**Project Name:** \* Bridge 9 over South River on US 13

Subject: **Request for Additional Information for T.I.P. B-4635 (Replacement of Bridge 9 over South River Overflow on US 13, Sampson County)**

Below are responses to needed additional information and corrections to previously submitted items for the permit application for B-4635 (Replacement of Bridge 9 over South River Overflow on US 13, Sampson County)

PERMIT DRAWING
SHEET 17 OF 18

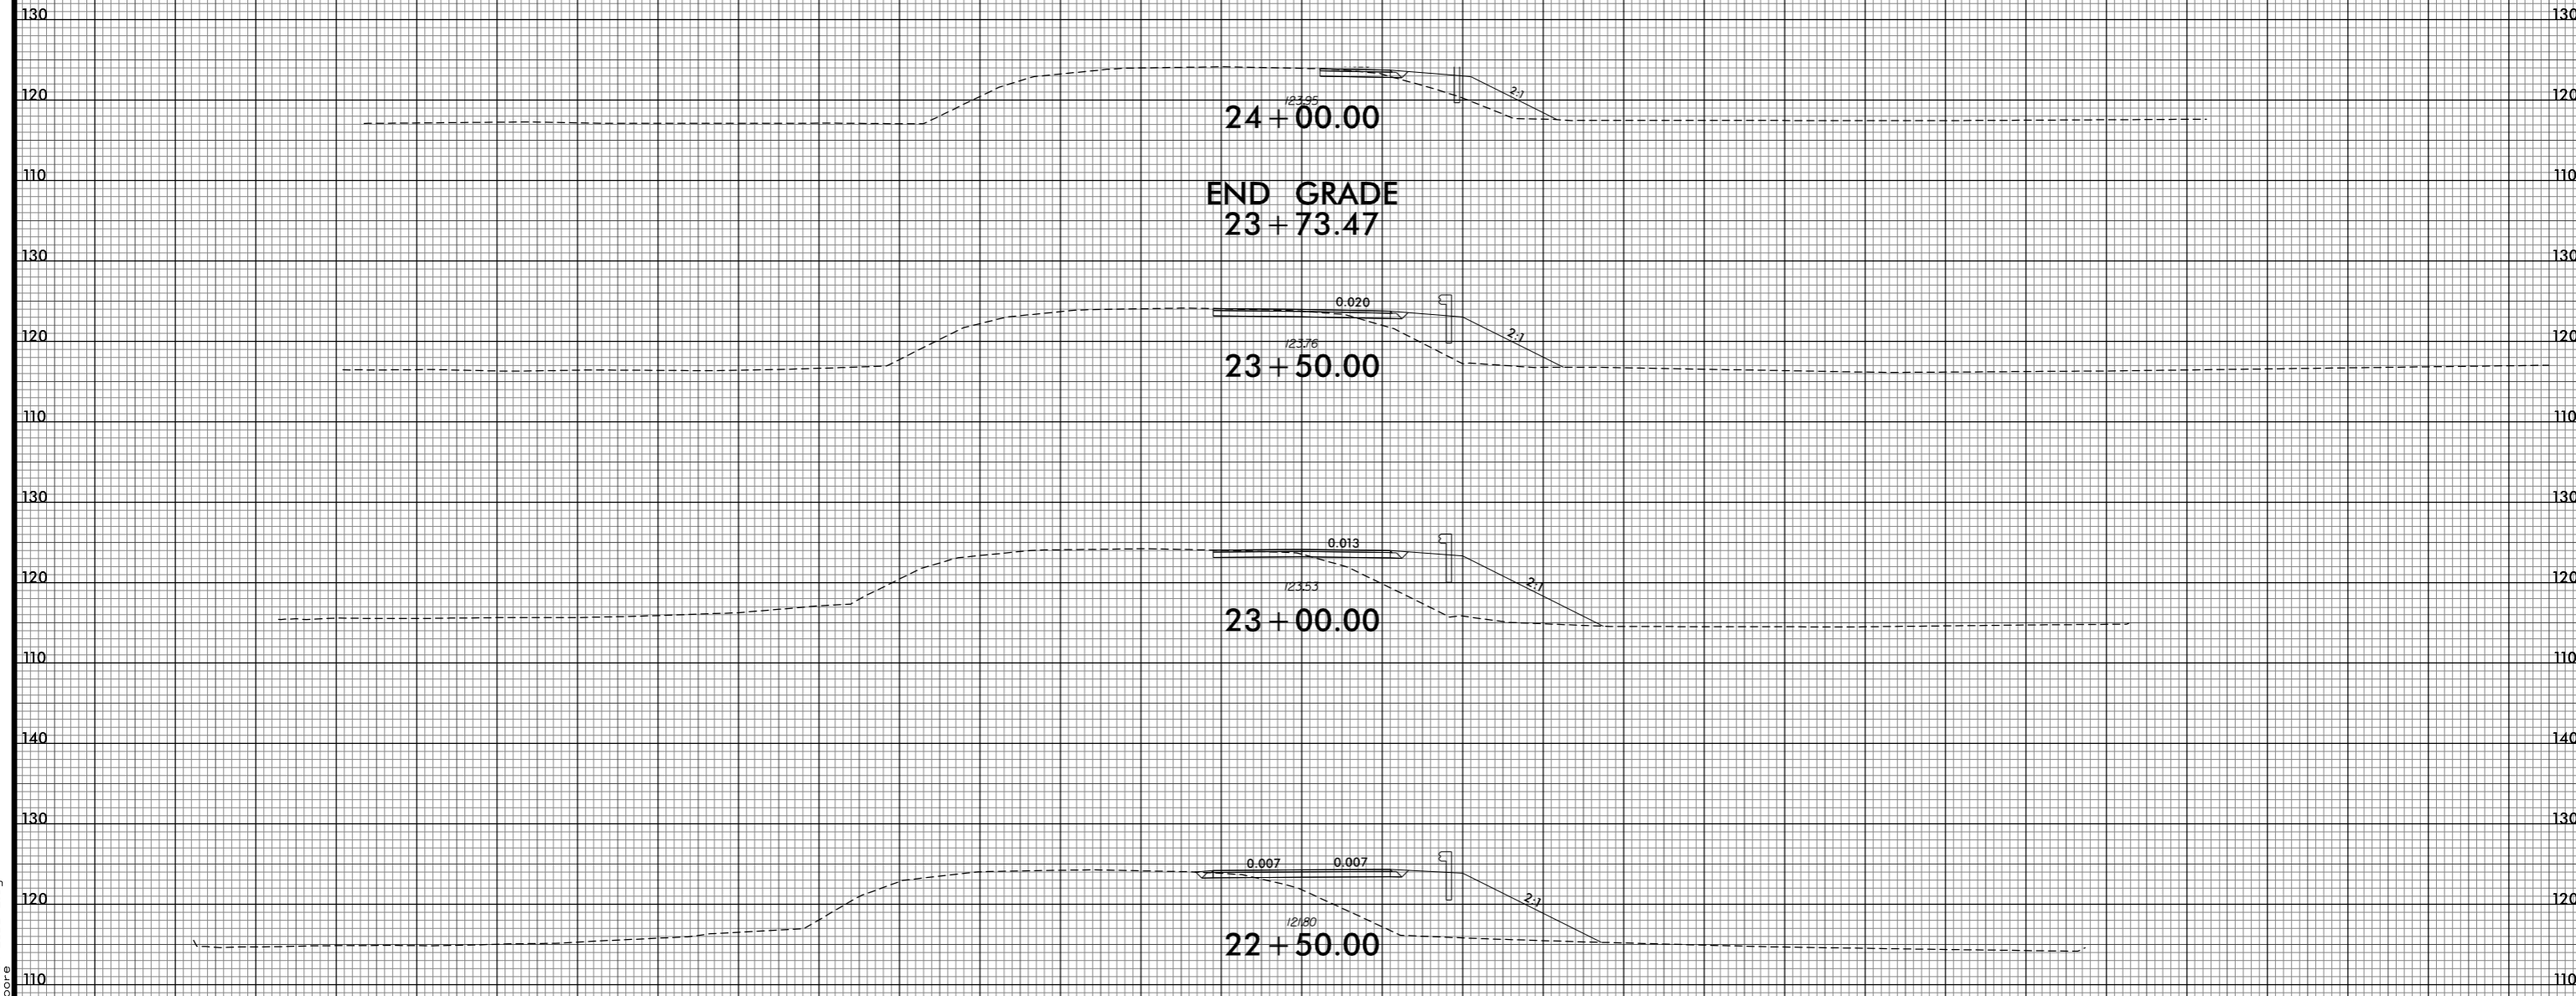
-there is no slope listed in the cross section drawings regarding the temp detour which leads to the question, could the slope be steeper than 3:1 since it would most likely be constructed with a rock base thus reducing the amount of temporary impact? **Cross sections of the detour are included in revised drawings to show 2:1 slopes along the detour.**
